## Application for Removal or Variation of a Condition following Grant of Planning Permission or Listed Building Consent

Proposal: Erection of a first floor rear extension over shop and insertion of window in west elevation  
Location: 20A Queen Street, Deal, CT14 6ET

22/00387

**DRAWING TITLE**  
**Proposed layouts and elevations**

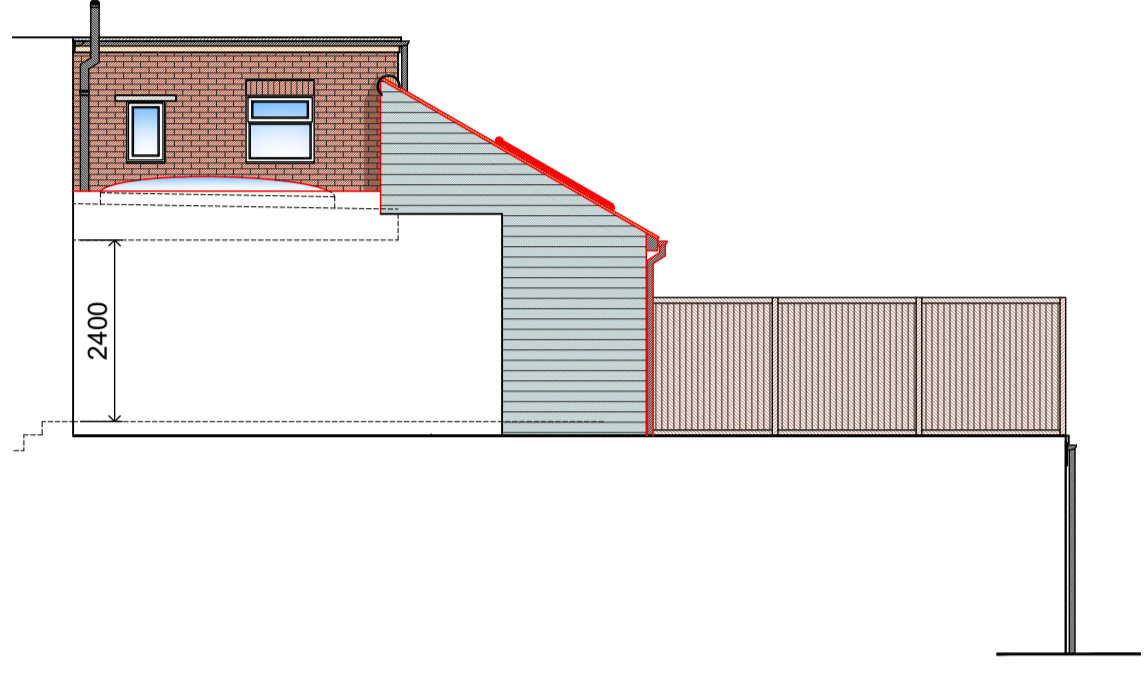
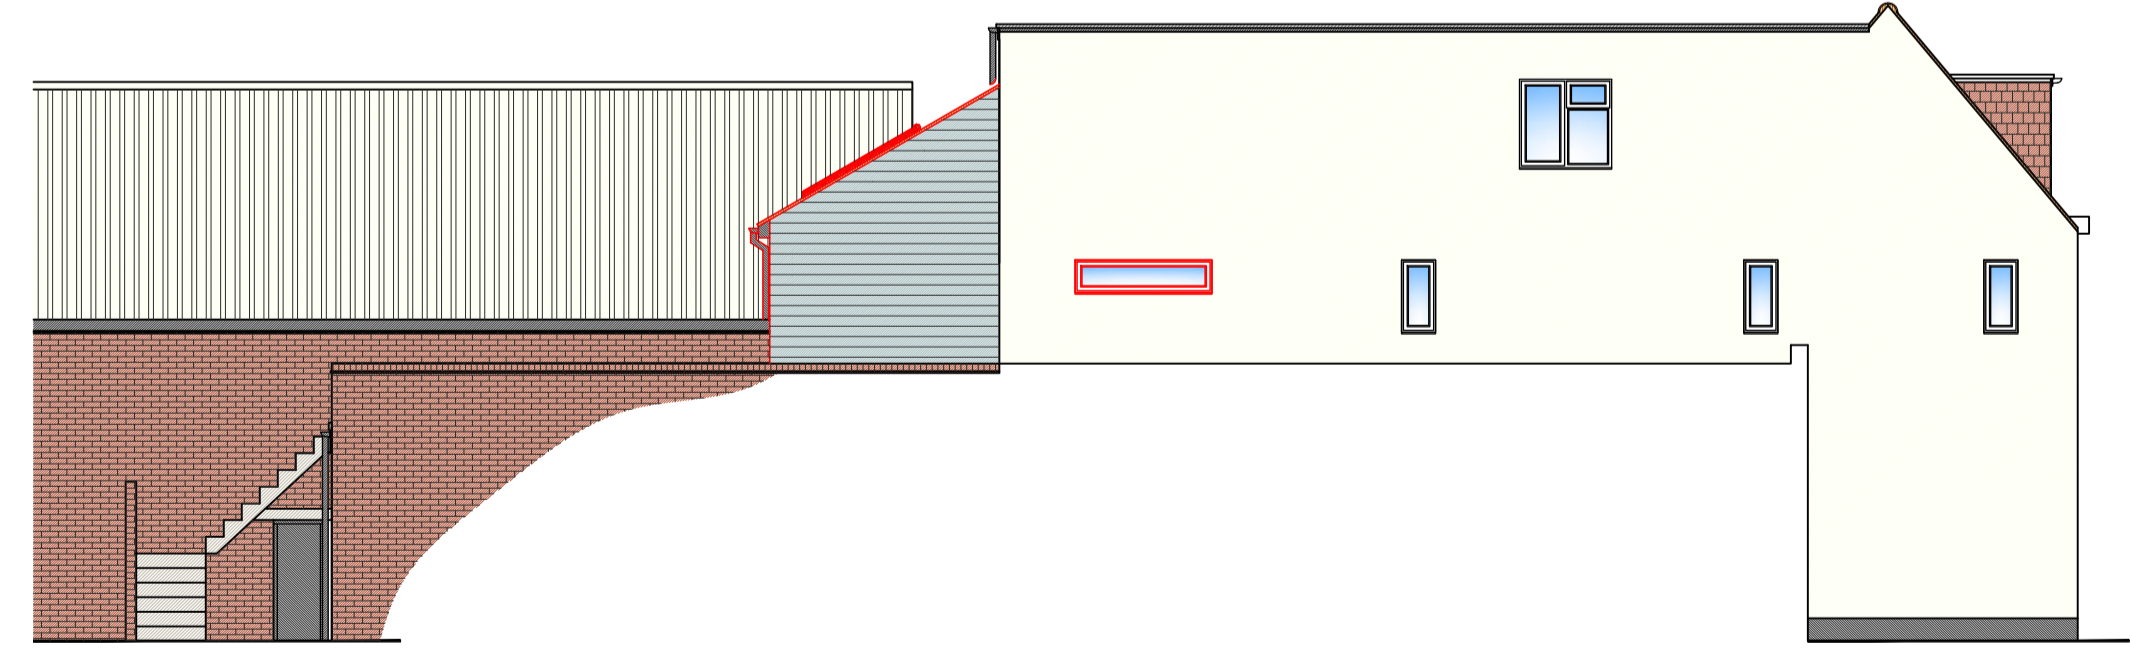
We are looking to reduce the weight of the proposed extension. To do this we have removed the brickwork from the side elevations and replace with the same weatherboard cladding on the rear elevation. We are also replacing the insulated roof panel system on the pitched roof to traditional slate tiles.

2 The development hereby permitted shall be carried out in accordance with Drawing MANSE-21-084-02 D received 19 January 2024.  
Reason: For the avoidance of doubt.
